4 December 2024

DPIE request for Advice –Maison Dieu Solar - SSD 48160216

I refer to your request via the NSW Major Projects Planning Portal for advice from Singleton Council on the Environmental Impact Statement (EIS) for the Maison Dieu Solar Farm (SSD 48160216). Council notes that the due date for submissions was 9th October 2024.

Above: Aerial view of Port of Newcastle, Mayfield Berth 4. Below: Site overview of Maison Dieu Solar Farm including OSOM access location (marked A).

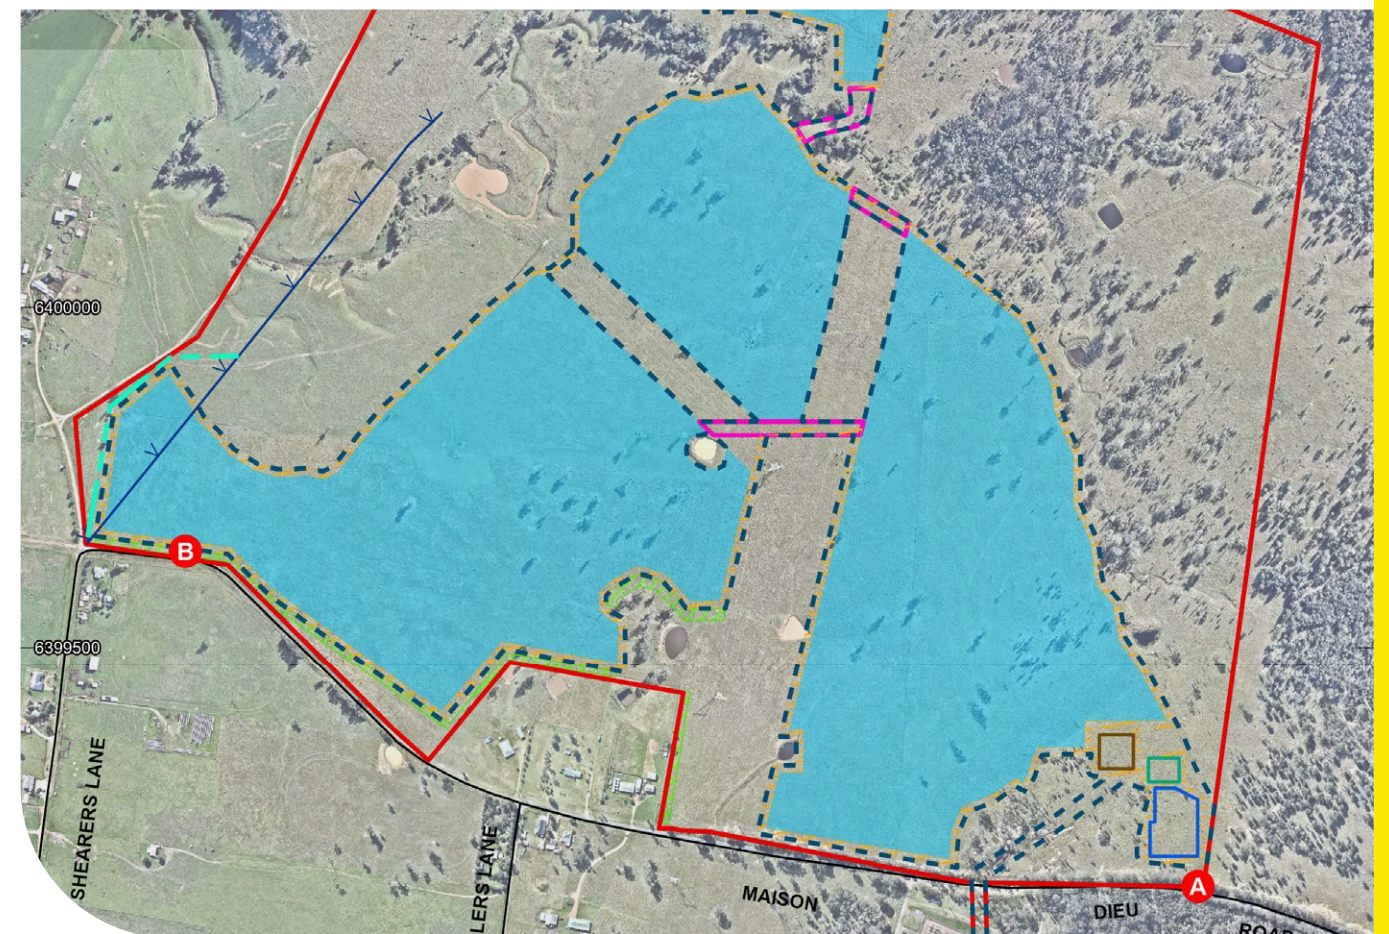
- Swept path analysis is required for the main temporary construction access (Access A). The TIA states that this access is to be constructed in accordance with AS2890.2-2002 and is therefore suitable for use by heavy vehicles and no swept path analysis is required. However, the OSOM Route Study indicates that the largest loads (switch rooms) that will turn into site may require a larger turning path than the standard layout specified in AS2890.2-2002. The swept path analysis for the main temporary construction access (Access A) is to be provided to Singleton Council prior to the commencement of construction.

LEFT TURN
New England Hwy
& Magpie St

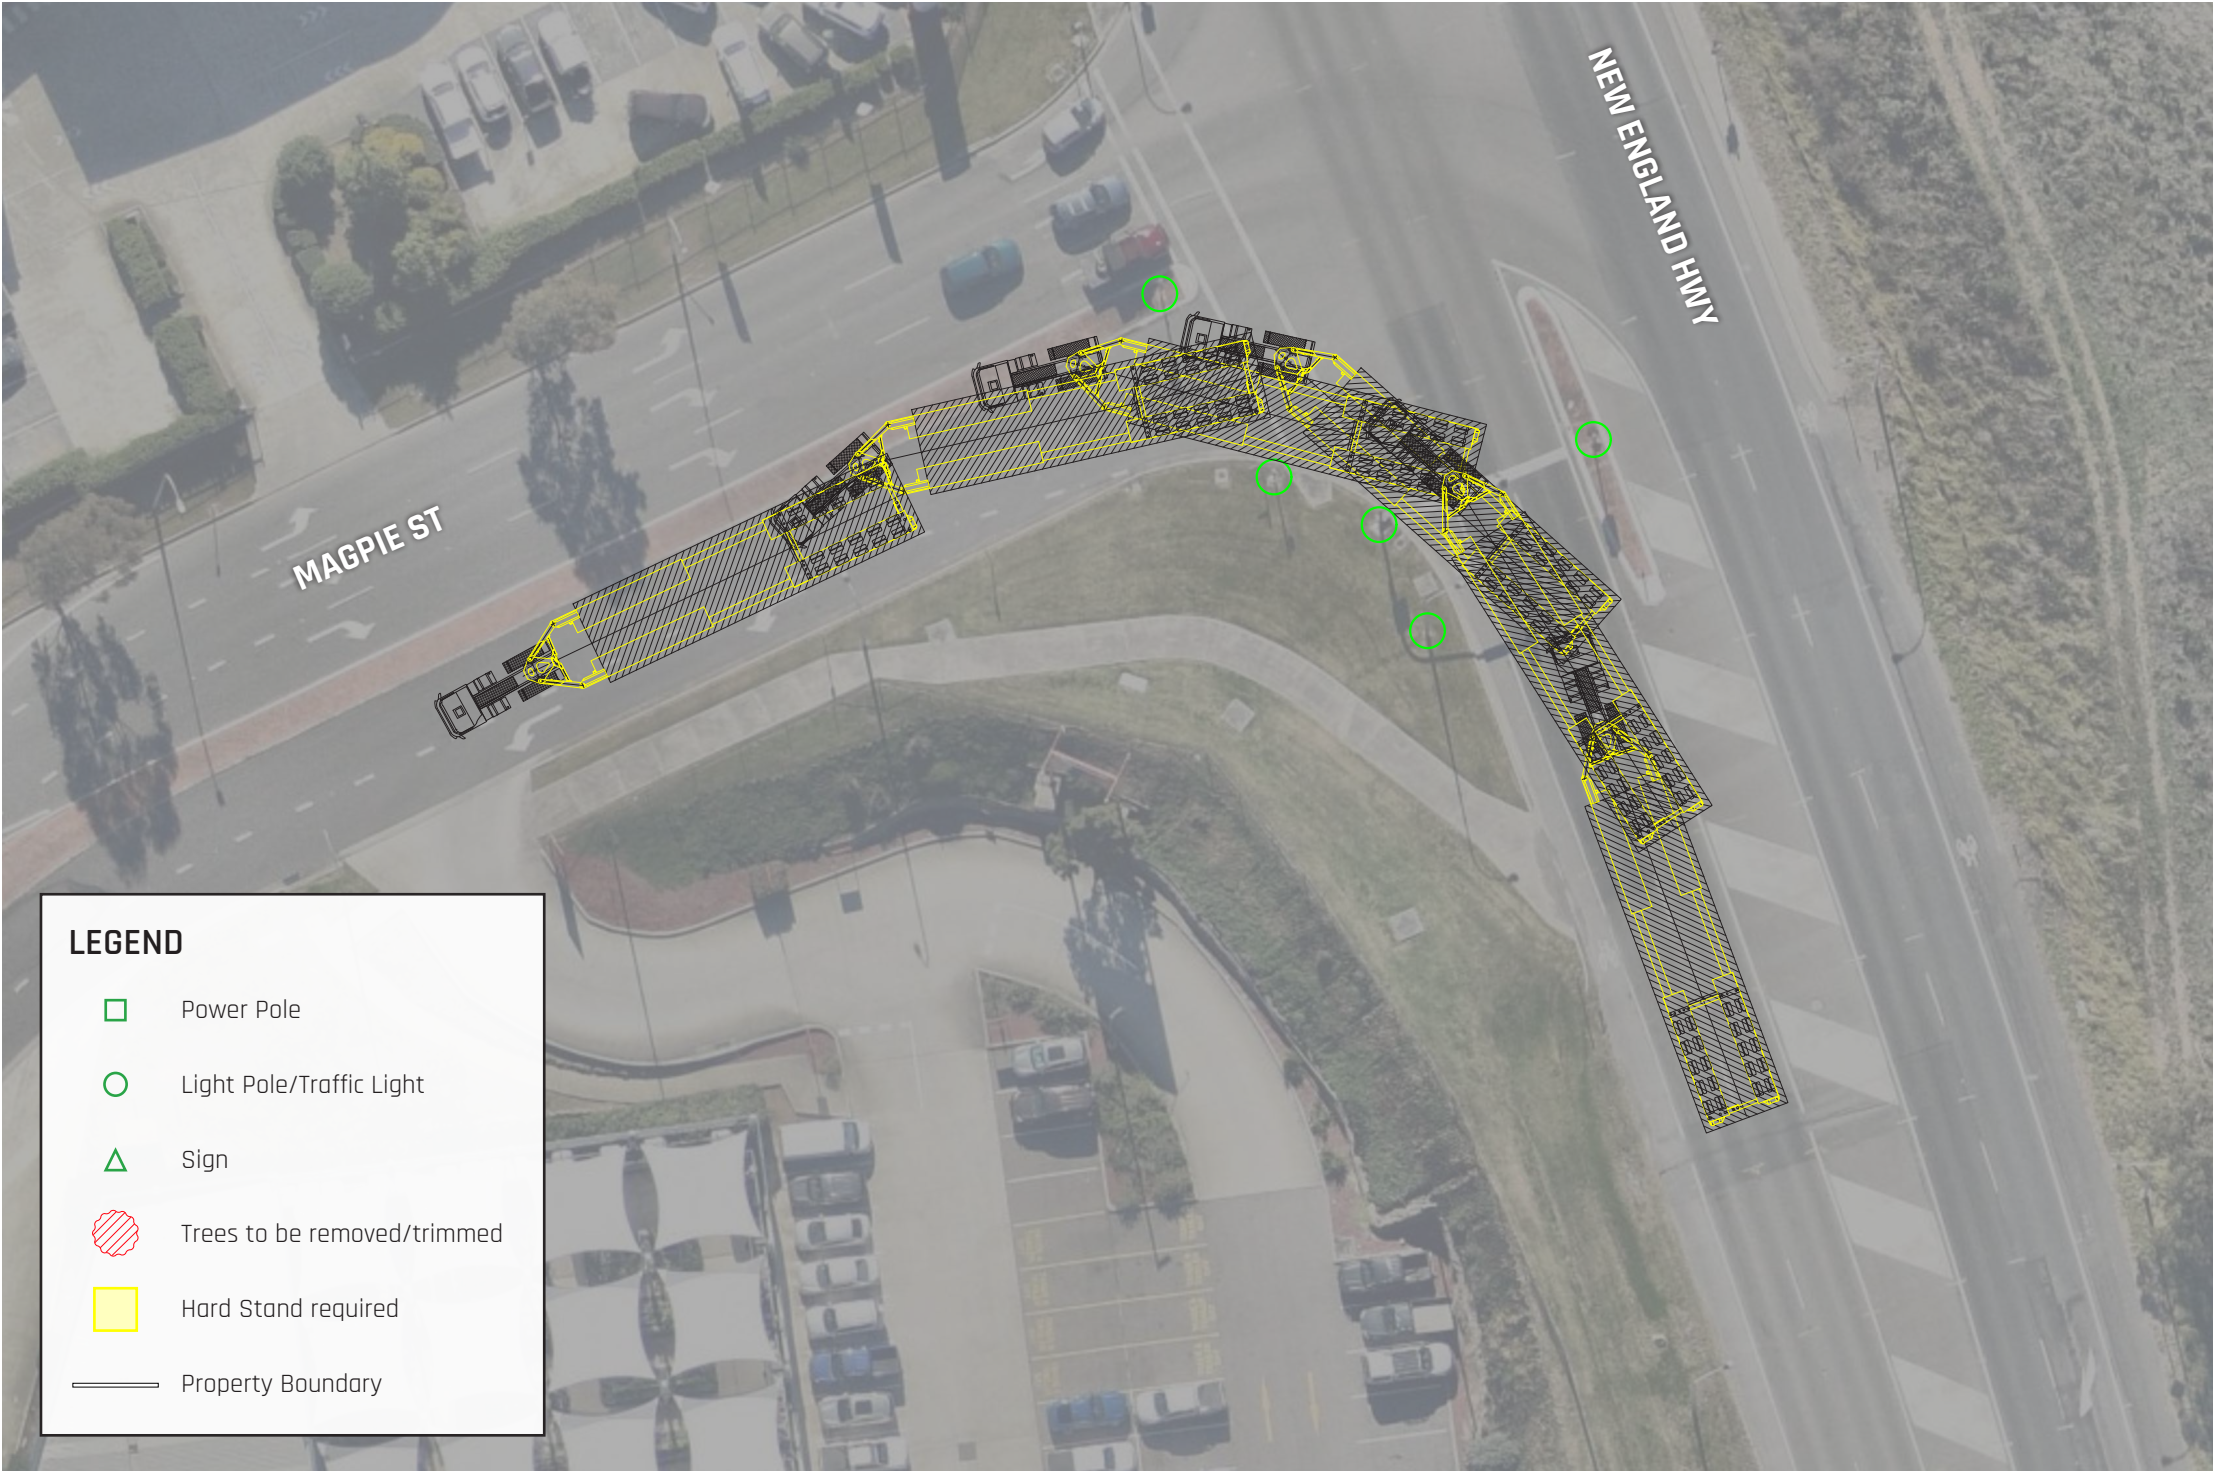
- The OSOM Route Study indicates that the OSOM loads will overrun the median island on Magpie Street. A dilapidation report (pre and post construction) must be prepared for the median island on Magpie Street to identify any pavement damage caused by the OSOM movements associated with the project. The applicant must repair any damage to the median island or associated infrastructure to Council's satisfaction post construction.
